Application by RiverOak Strategic Partners to upgrade and reopen Manston Airport
The Examining Authority's written questions and requests for information (ExQ1)
Issued on 18 January 2019

Figure D Impact on NO₂ Concentrations from on-Airport Activity in the Peak Activity Year (Year 20)

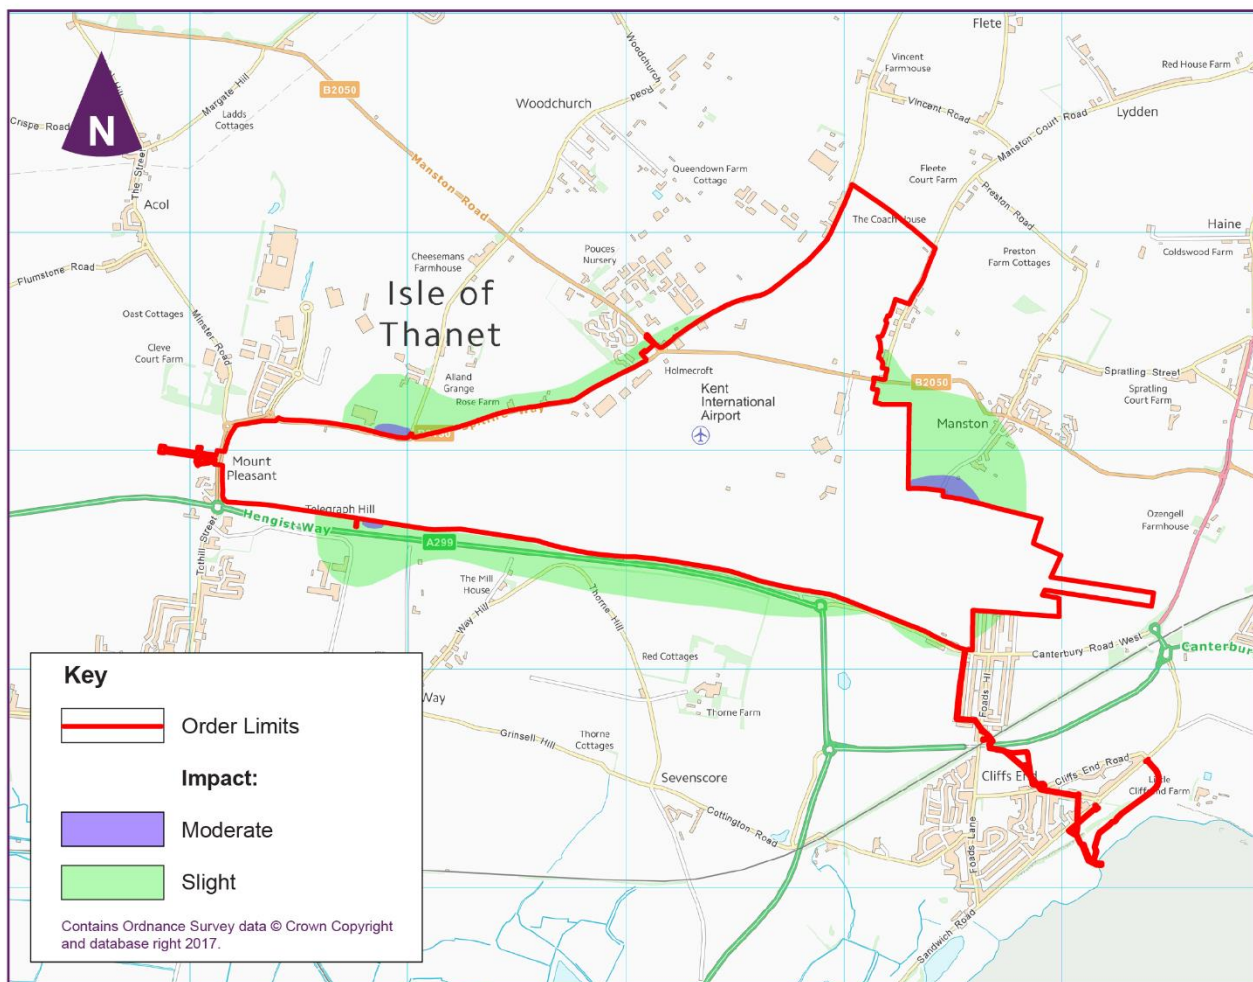
AQ.1.3	The Applicant	<p>Figure 9.1: Impact on NO₂ concentrations from on-airport activity in the peak activity year (Year 20)[APP-080] Quantify what is meant by "moderate" in this Figure.</p>
AQ.1.4	Natural England	<p>Air quality impacts on designated ecological sites Paragraph 9.118 of the Planning Statement [APP-080] states: <i>"In terms of impacts on ecological sites, some exceedances of the annual</i></p>
